Ref: D2017/094379

Kate Masters
Senior Planning Officer, Waste
Industry Assessments
Department of Planning & Environment
GPO Box 39
Sydney NSW 2001

**Woodlawn Bioreactor Modifications (MP 10_0012 MOD 2 and DA 31-02-99 MOD 3)
Submissions on Modification Application**

Groundwater MB-10; Key Parameters 1996 to 2016

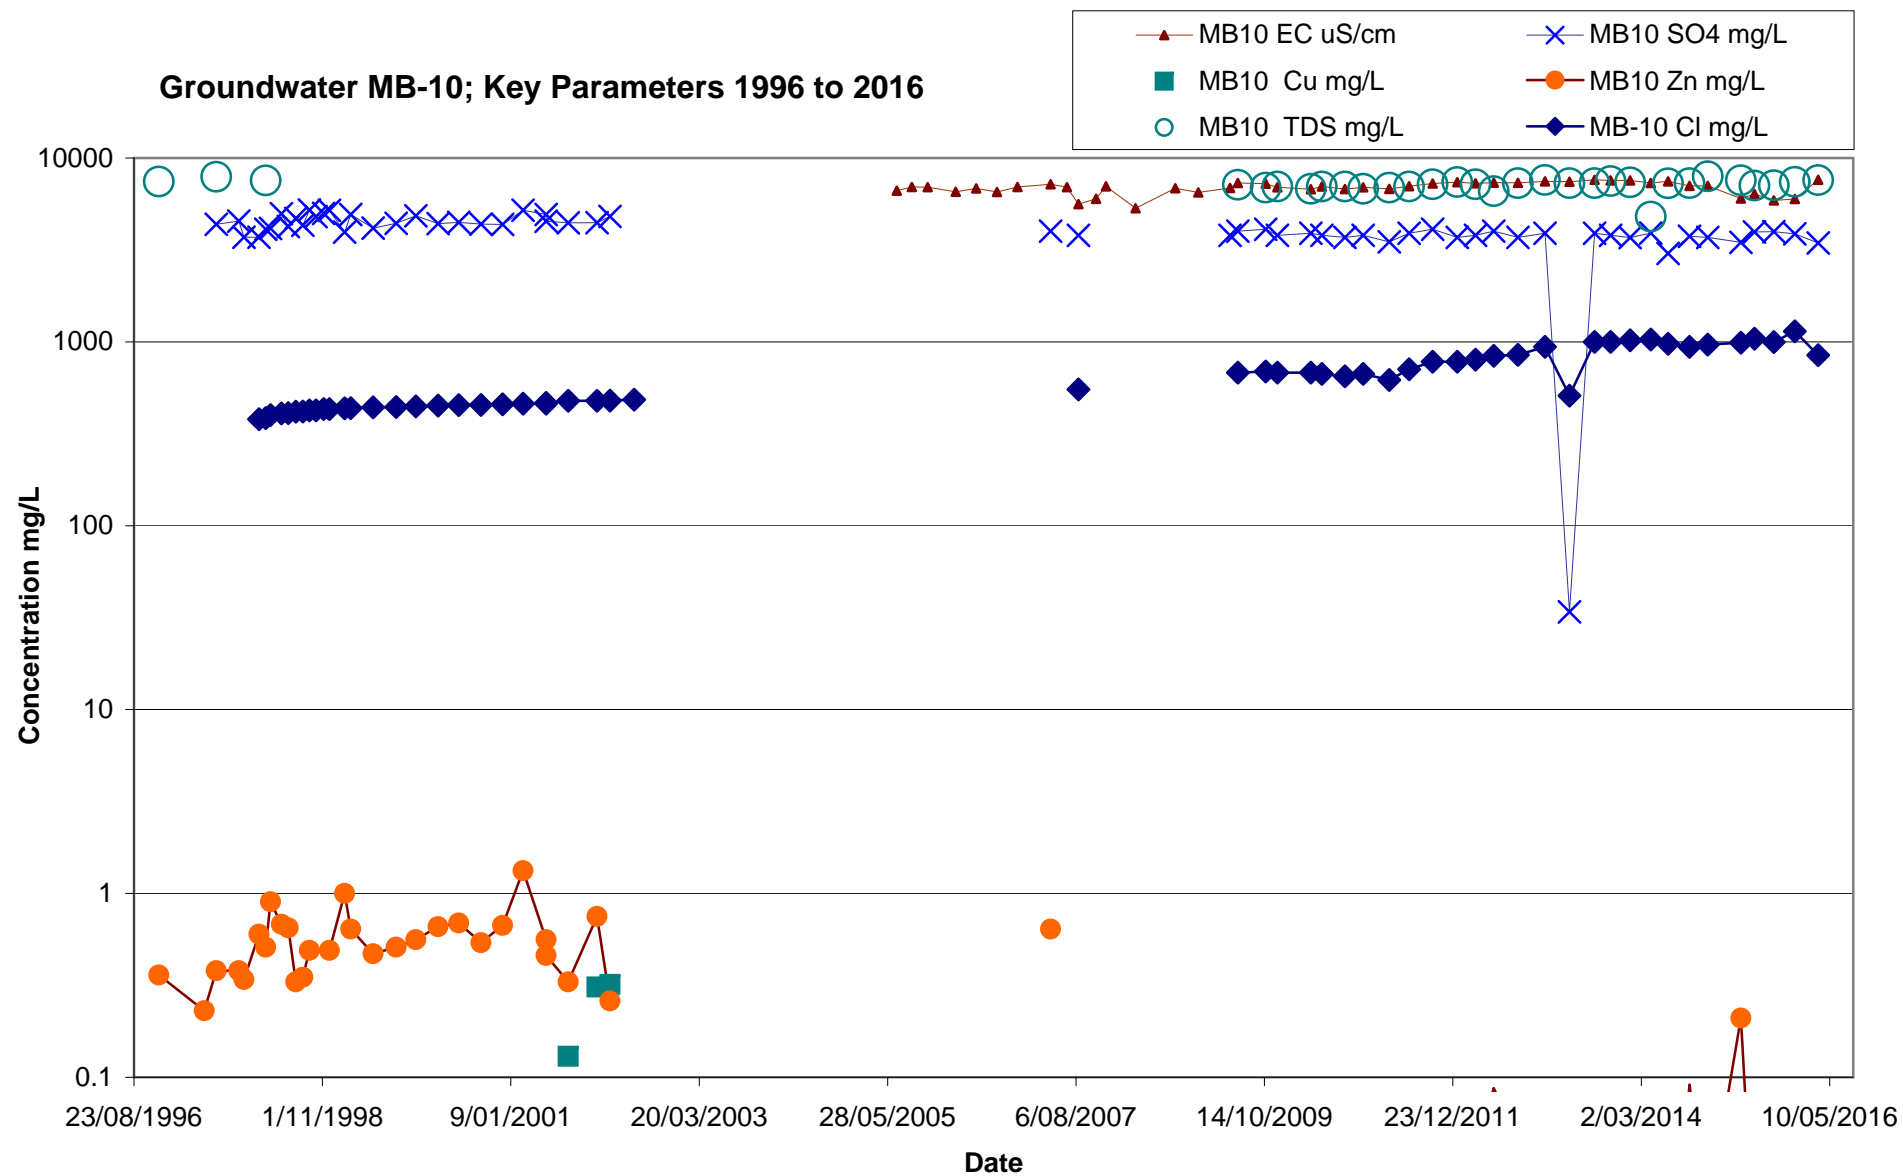
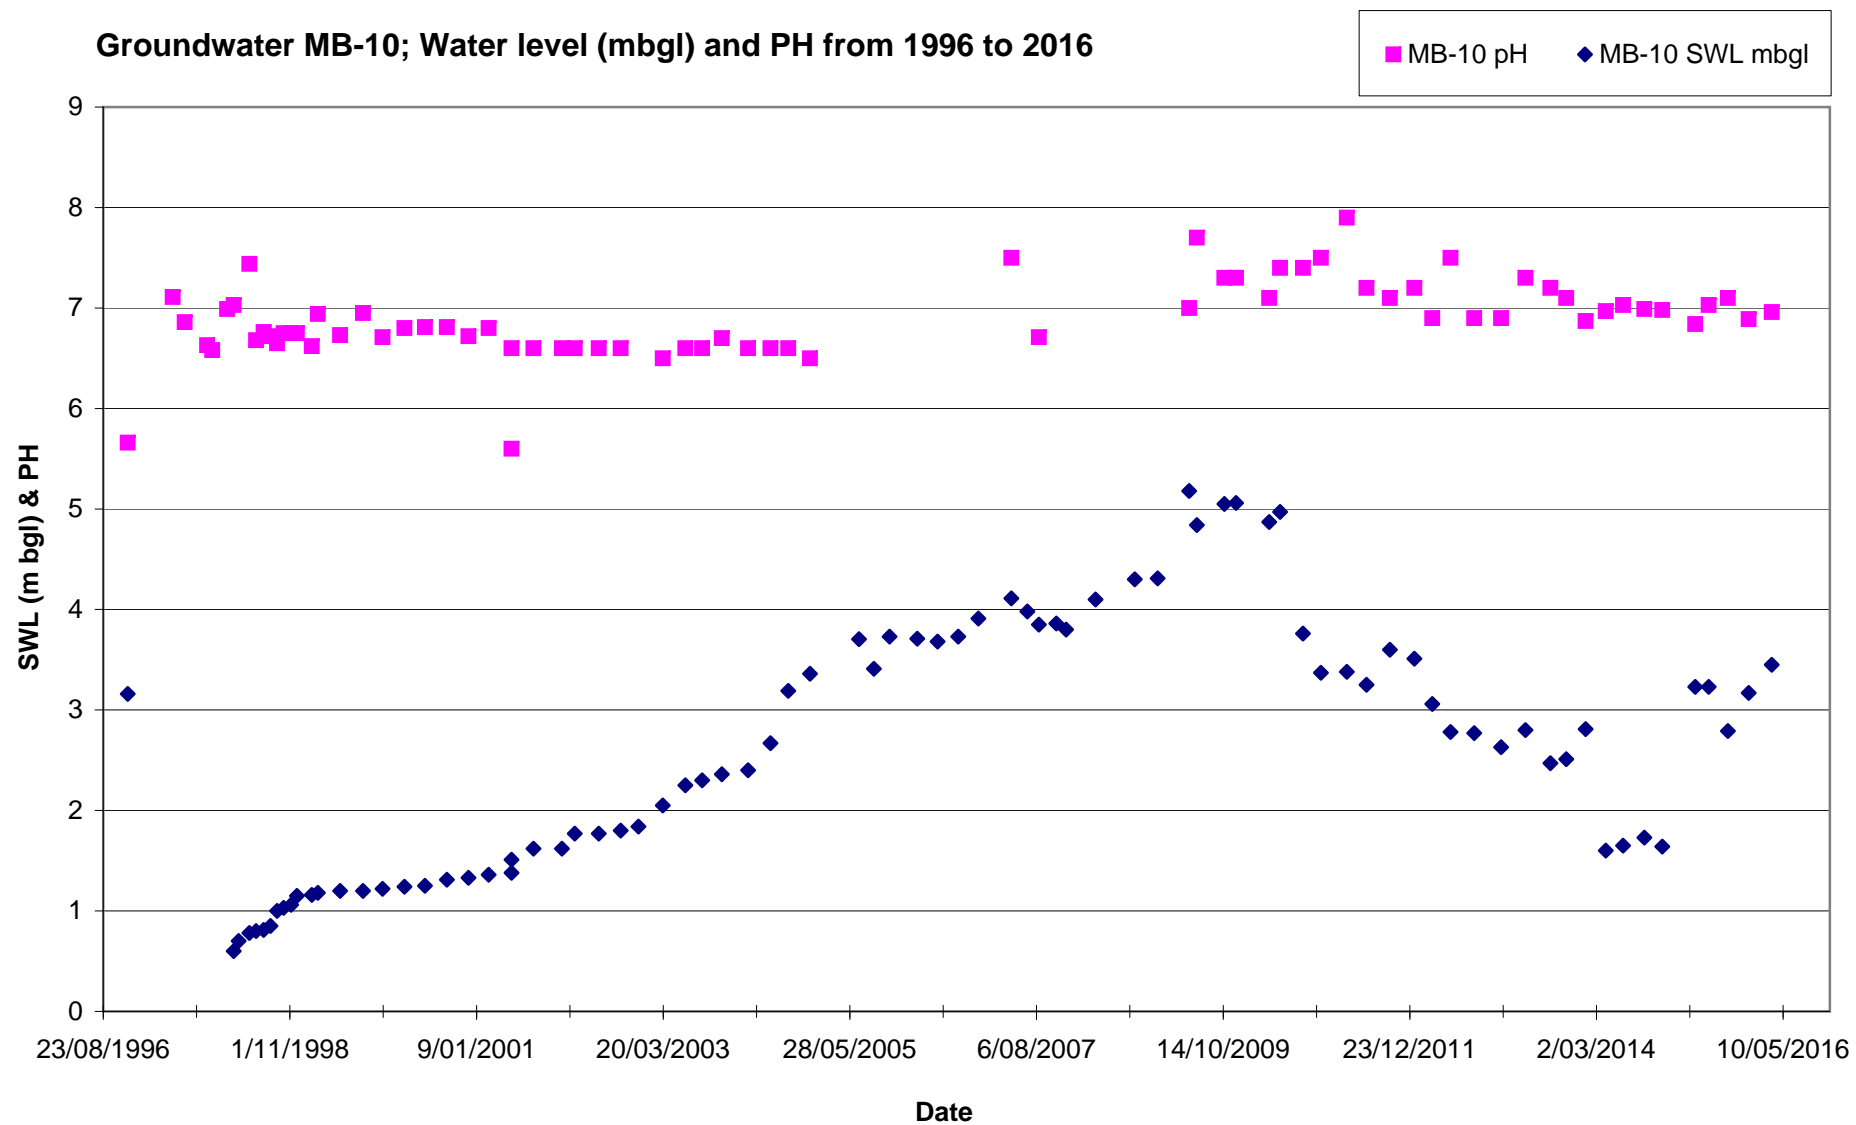
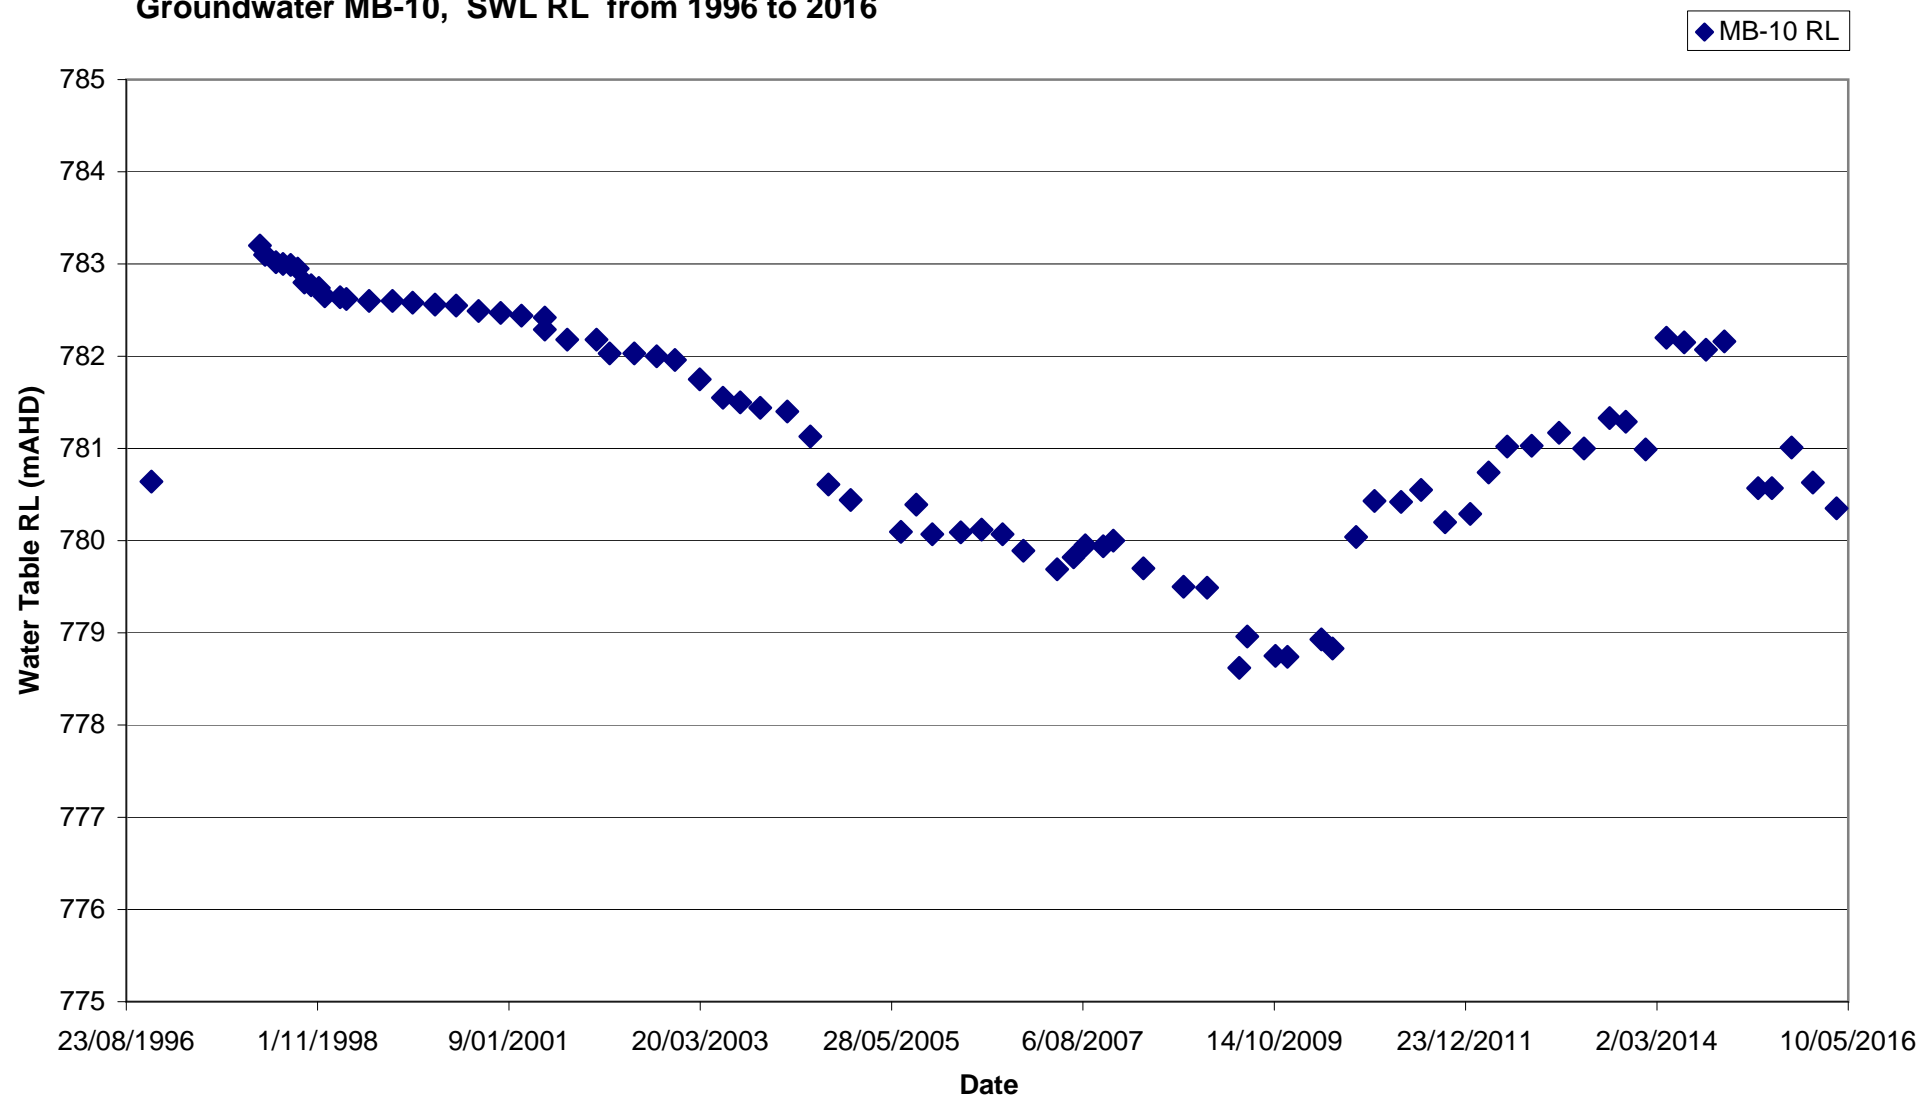
A comparison of groundwater monitoring bore (MB10) standing water level (SWL) from 1996 to 2016 with the pond storage in water balance for ED1 (Parson Brinkerhoff, 22 July 2016)), shows a strong correlation between ED1 storage volume and the SWL of the groundwater in monitoring bore MB10 (see graphs in Attachment 1).

A significant increase in the volume of contaminated mine water or leachate in ED1 will potentially increase the amount of seepage discharged under the dam towards Crisps Creek.
